Your ref:
Our ref: 21/02427/F
Please ask for: Mrs Lesley Raby
Direct dial: 01553 616818
Direct fax: 01553 616652
E-mail: borough.planning@west-norfolk.gov.uk

Details: **Retrospective renovations and repairs to existing utilities building. at The Old Post Office Walsingham Road Burnham Thorpe Norfolk PE31 8HL**

WASH SHED  
REPAIRS & RENOVATIONS  
OLD POST OFFICE

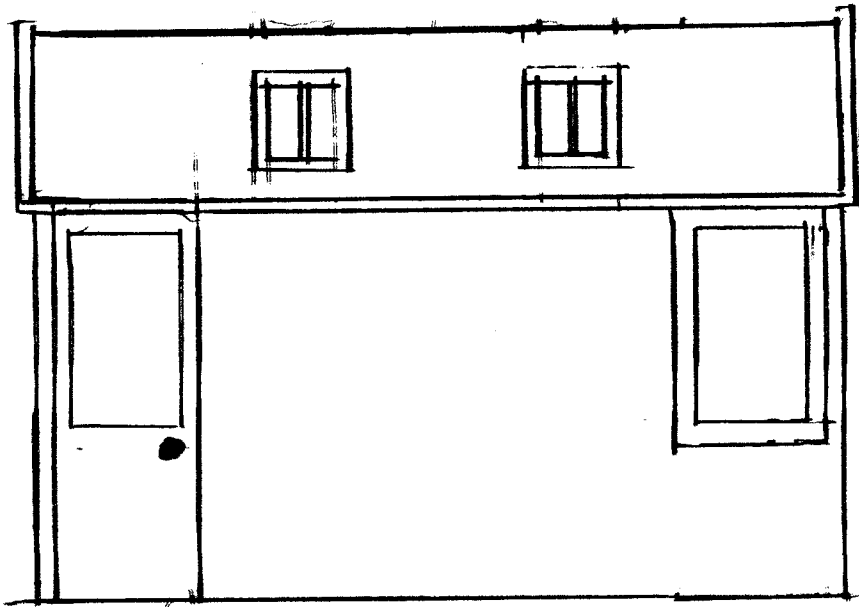
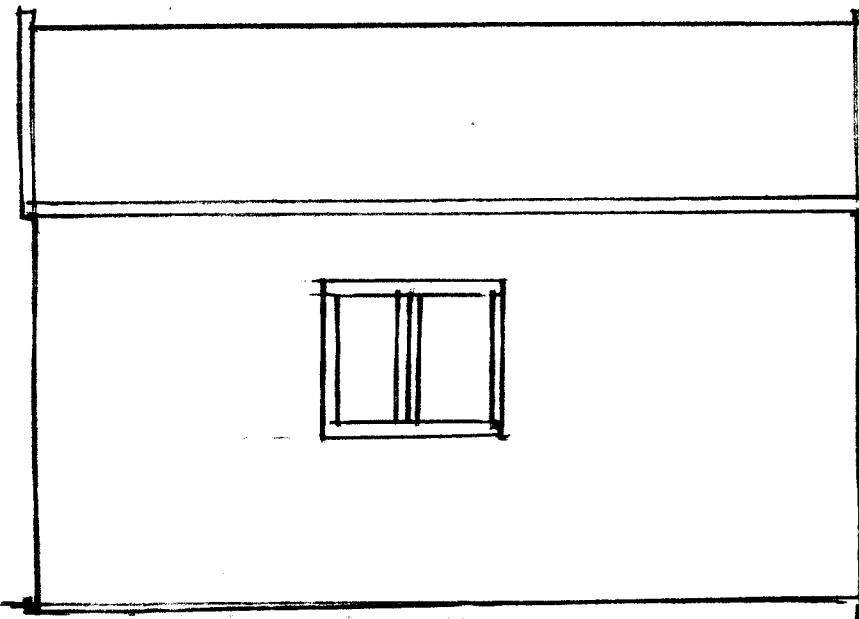
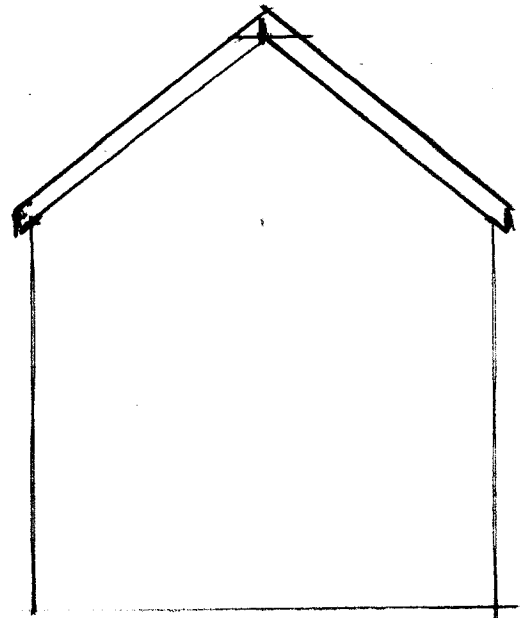
4. Provide the existing and proposed roof plan.
5. Confirm the scale of the elevation plans you have submitted as they don't appear to match the measurements on the block plan.
